From: David Spring <David.Spring@arun.gov.uk>
Sent: 20 April 2020 17:06
To: Planning.Responses <Planning.Responses@arun.gov.uk>
Subject: FW: LU/2/20/PL - Town Council Comments

Subject: LU/2/20/PL - Highways Comments

Block Plan

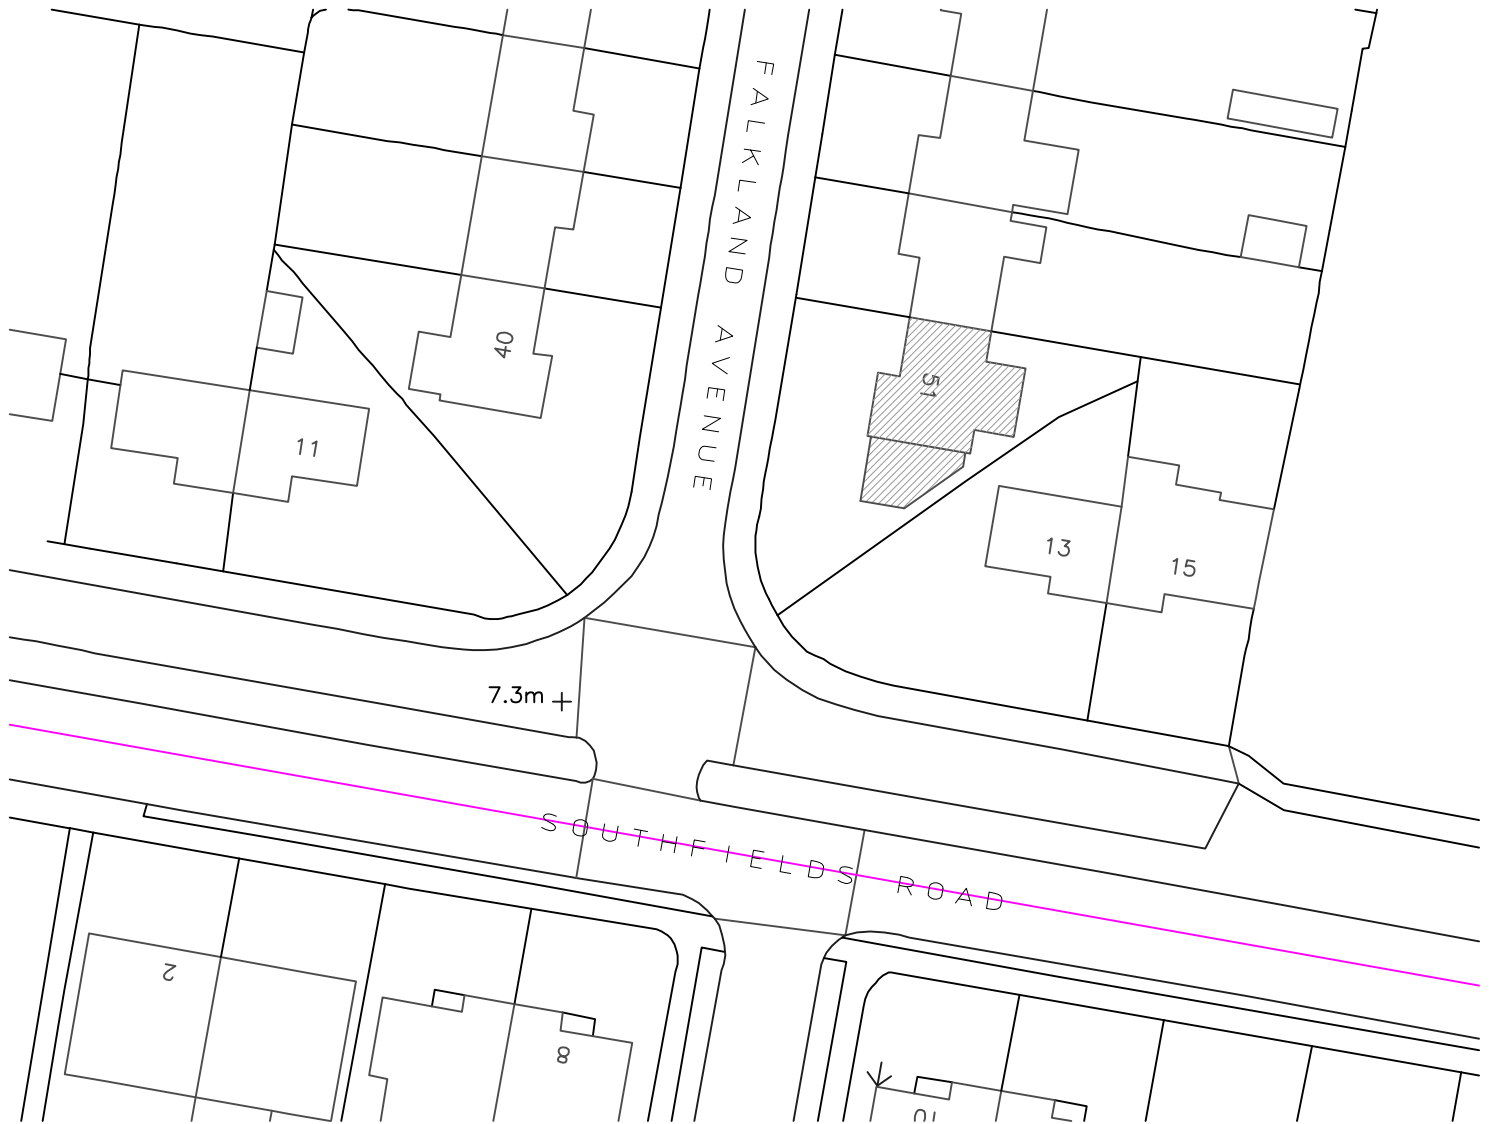
Please find the Highway comments attached. They are not objecting but do recommend a few conditions. One thing they would like changed is in terms of access, outlined below:

'Access

This proposal includes construction of two additional vehicle crossovers (VCO) to accommodate the proposed parking provision. I have consulted the Area Manager to provide their comments in relation to the proposed VCO. They have advised that rather than two separate VCOs, the full height kerb between the two proposed VCOs should be dropped, providing a wider, shared VCO. Any access works onto the public highway must be constructed under a licence obtained from WSCC Highways to a specification agreed with them'.

Could you send in an amended plan incorporating this wider single vehicle crossover please?

| Rev                                                                                                            | Description    | Date                                                       |
|----------------------------------------------------------------------------------------------------------------|----------------|------------------------------------------------------------|
| Scale: 1:100 @ A3                                                                                              | Dwg No: 160/01 | Drawn:      Date: 05.01.20                                 |

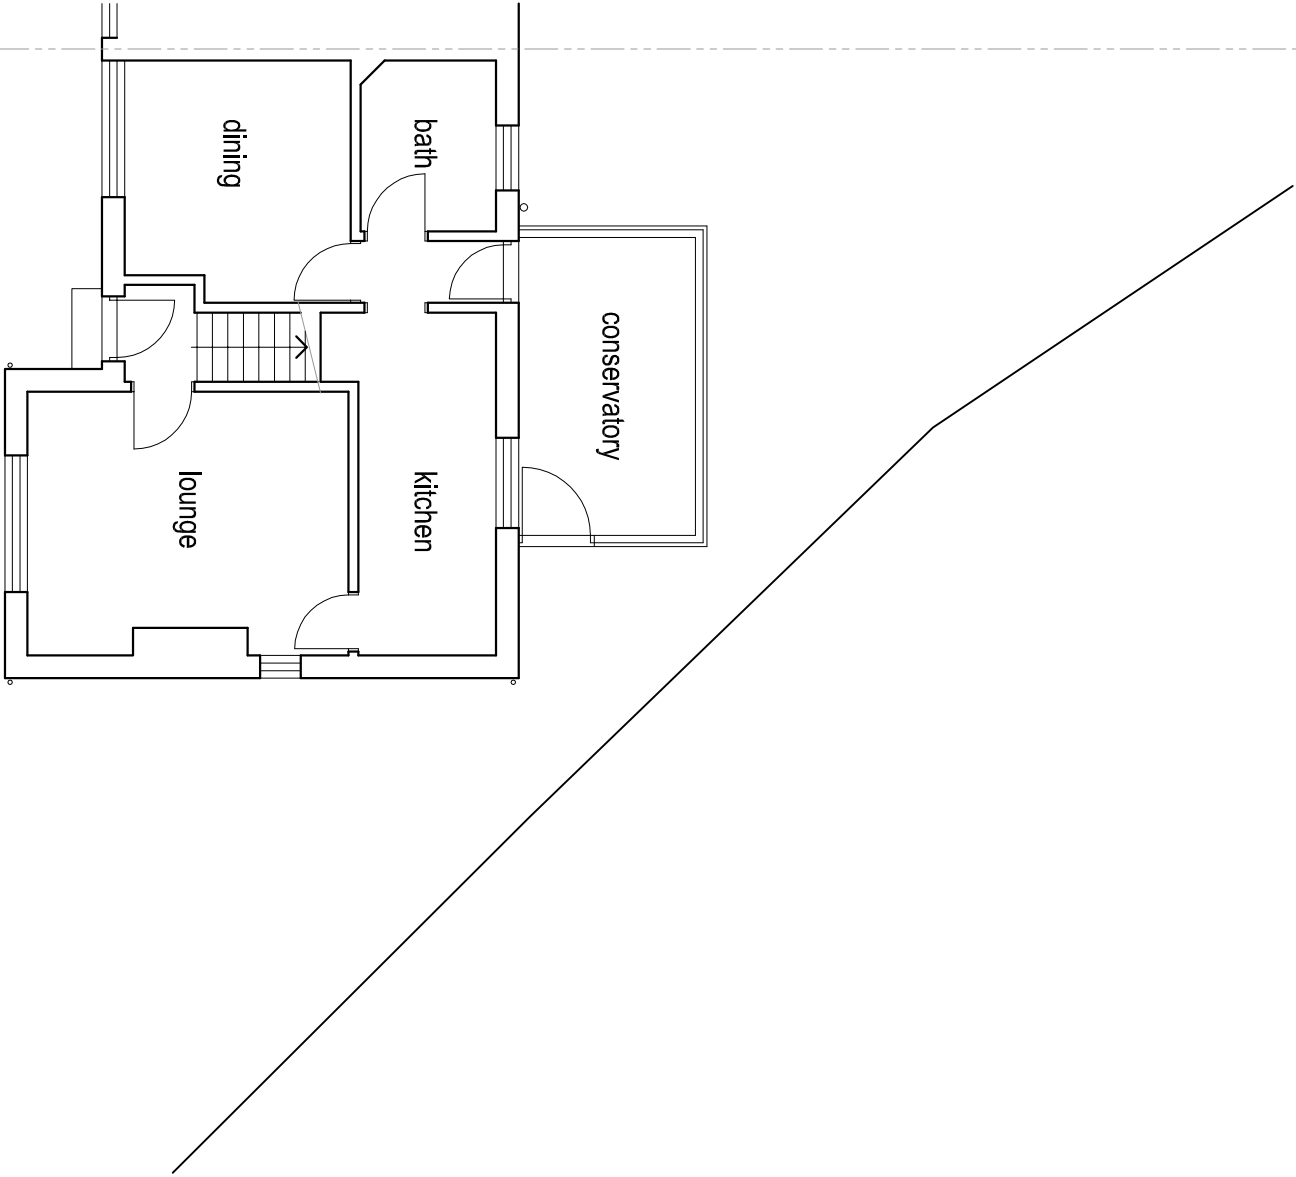
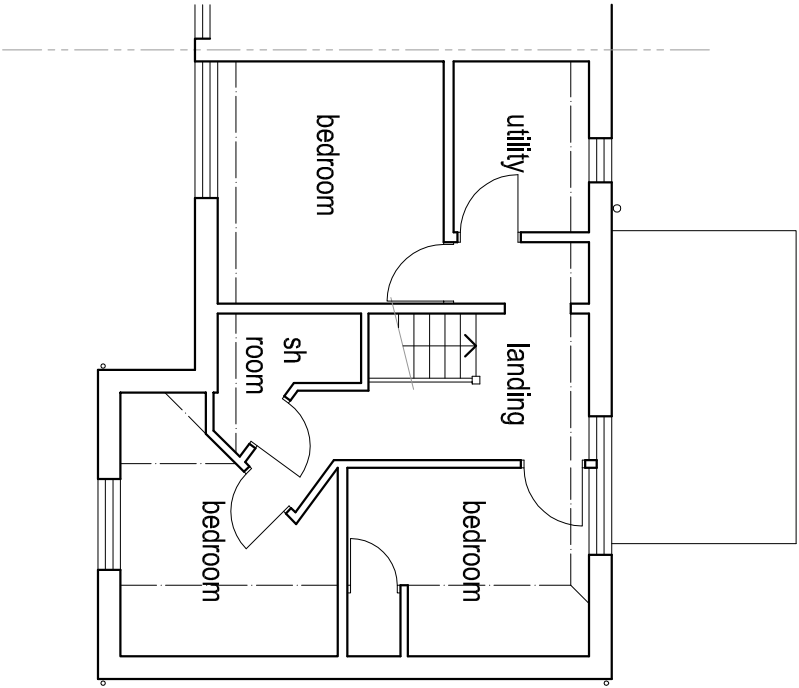
Unit 1: 39.5 sqm
Unit 2: 41.2 sqm
Unit 3: 38 sqm

Unit 1 & 2 would satisfy the requirements if there are occupied by 1 person each.

Unit 3 would need to be at least 58 sqm as it's 2 storey so it's 20sqm short of requirements.

On this basis the application will be refused.

Is it possible to amend the application to 2 No two bedroom flats at just over 61m sq each.
